Item No. **Report of the Interim Director of Planning, Regeneration & Public Realm**

Address 11 BIRCHWAY HAYES

Development: Conversion of dwelling into 2 self-contained flats with the erection of a ground floor front extension and part single, part double storey rear extension

LBH Ref Nos: **75827/APP/2022/1355**

PROPOSED GF & FF LAYOUT
Scale 1:100

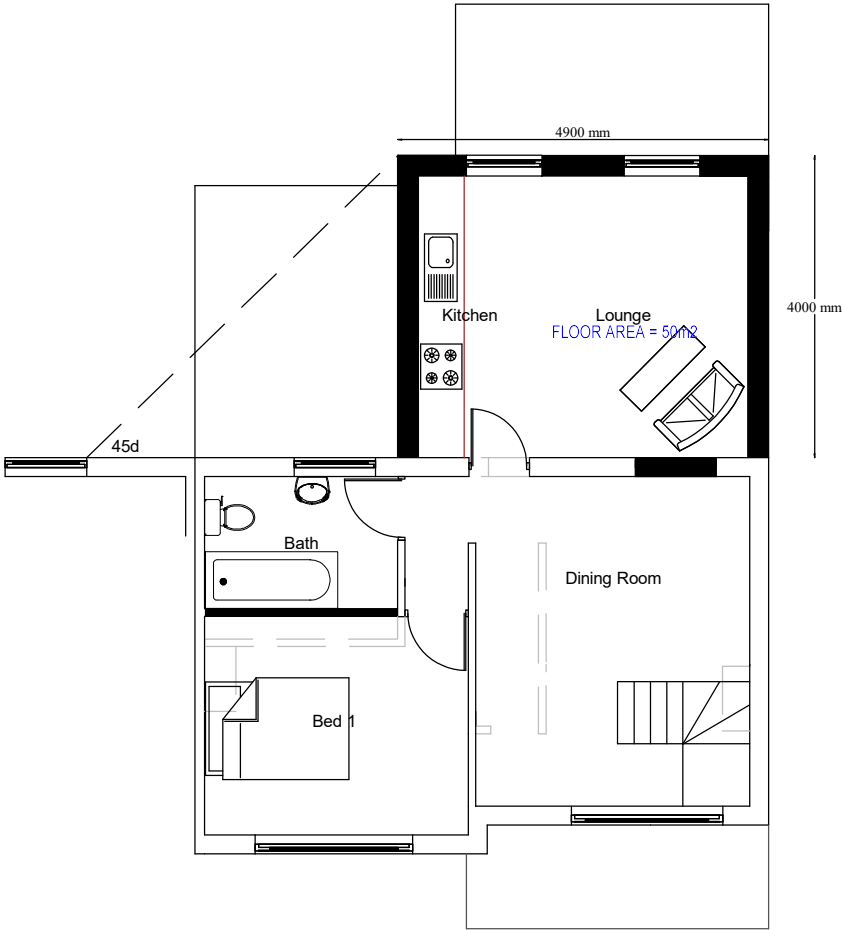
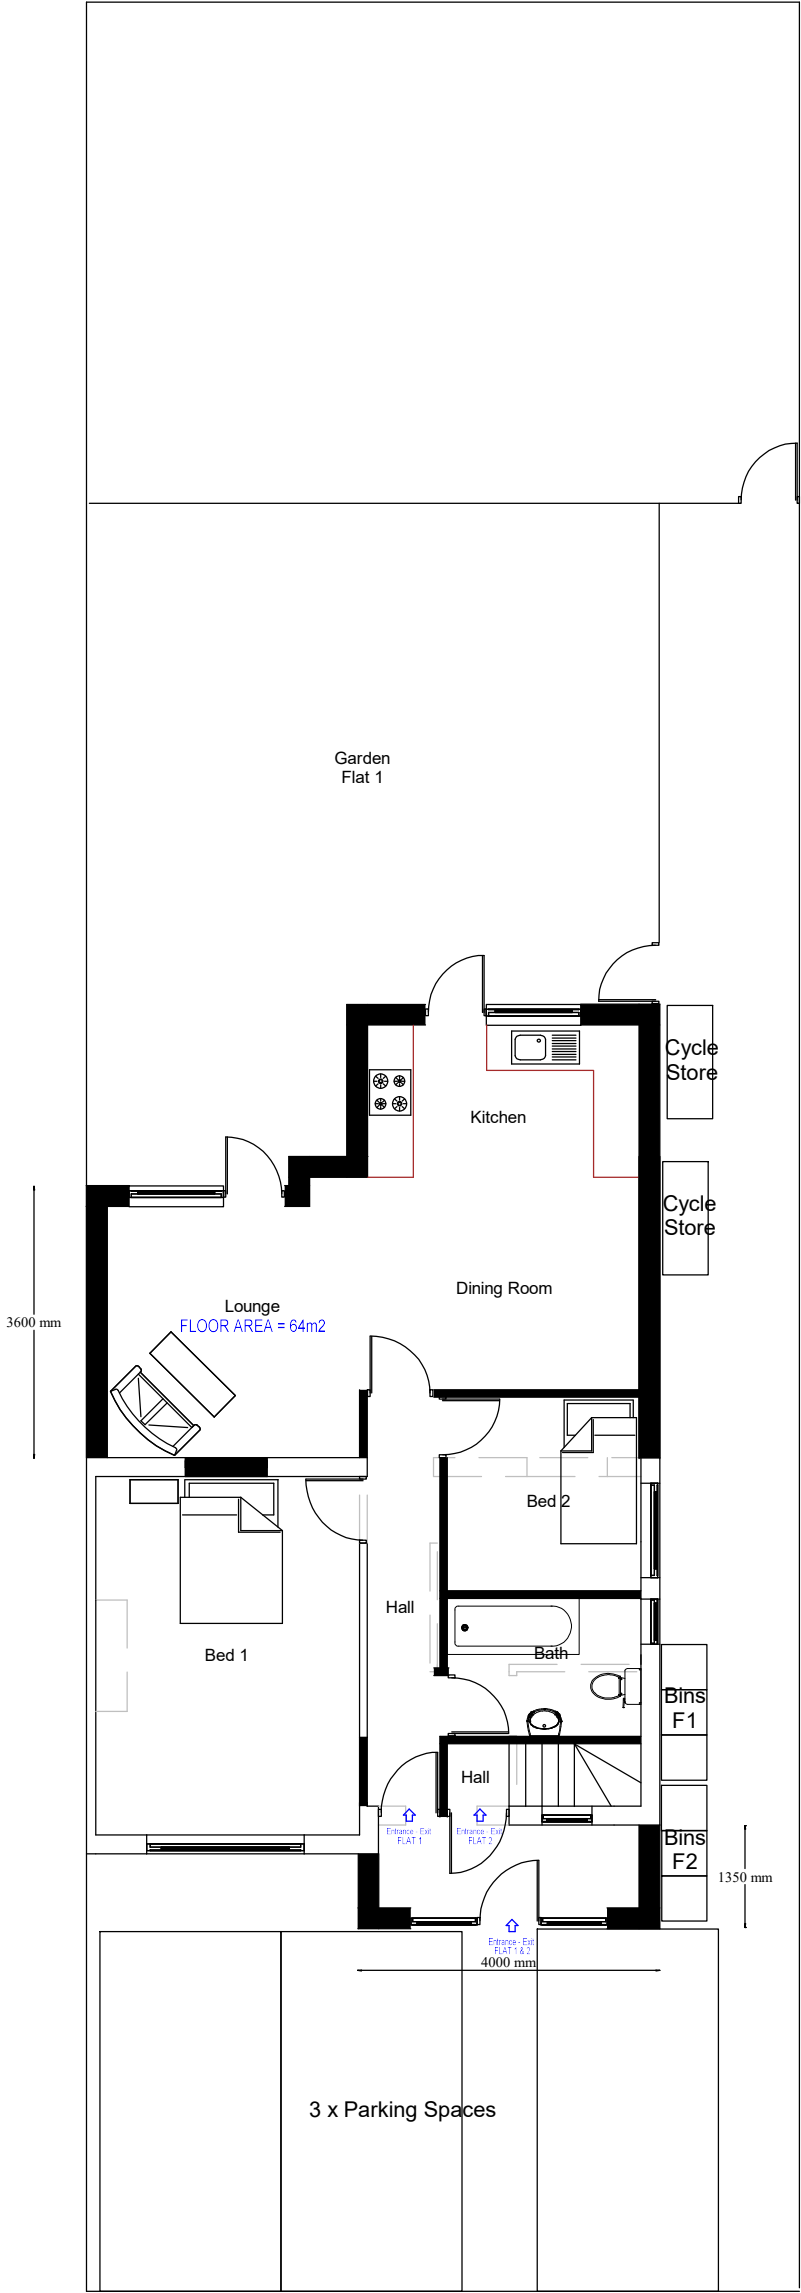
The proposed conversion of the existing three-bedroom single dwelling at number 11 Birchway into 1 x one-bedroom flat and 1 x two-bedroom flat would result in the loss of a residential unit that is suitable and appropriately sized (under 120sqm) for a family. The proposal would therefore unacceptably undermine the supply of family housing within the Borough, contrary to Policies DMH 1, DMH 2 and DMH 4 of the Hillingdon Local Plan: Part Two - Development Management Policies (2020), Policy H10 of the London Plan (2021) and the National Planning Policy Framework (2021).

The proposed part two storey, part single storey rear extension, by virtue of its design, size, scale, bulk, depth and height, would form a oversized and dominant addition to the original dwelling which would harm its architectural integrity and the character and appearance of the locality. The proposal is therefore considered to be contrary to Policies

The proposed part single, part two storey rear extension would be sited to the rear of the building where it would have no impact on the character or appearance of the area. Nevertheless the single storey rear extension would be a maximum of 6m deep at ground floor and 4m deep at first floor. The extension would engulf almost the entire rear elevation of the property, obscuring its original rear wall almost entirely, with a notable footprint. Due to its height, width, depth, bulky roof and footprint the extension is considered to form an oversized and disrespectful addition to the dwelling which would harm its character and appearance.

The proposed development includes an over provision of vehicle parking contrary to Policy T6.

Access to one of the proposed parking spaces would involve the removal of a tree which is outside of the development site. This is unacceptable.

Furthermore, the submitted plans show the creation of 3 parking spaces, this is likely to result in the creation of a full width crossover and dropped kerb at the front of the site. The crossover and parking arrangement would lead to the loss of an important tree (which as mentioned above is unacceptable). The full width cross over would also endanger pedestrians as there would be no middle point of refuge to stop while vehicles enter and exit the site. This would create a more hazardous environment for pedestrians and the sites car users.
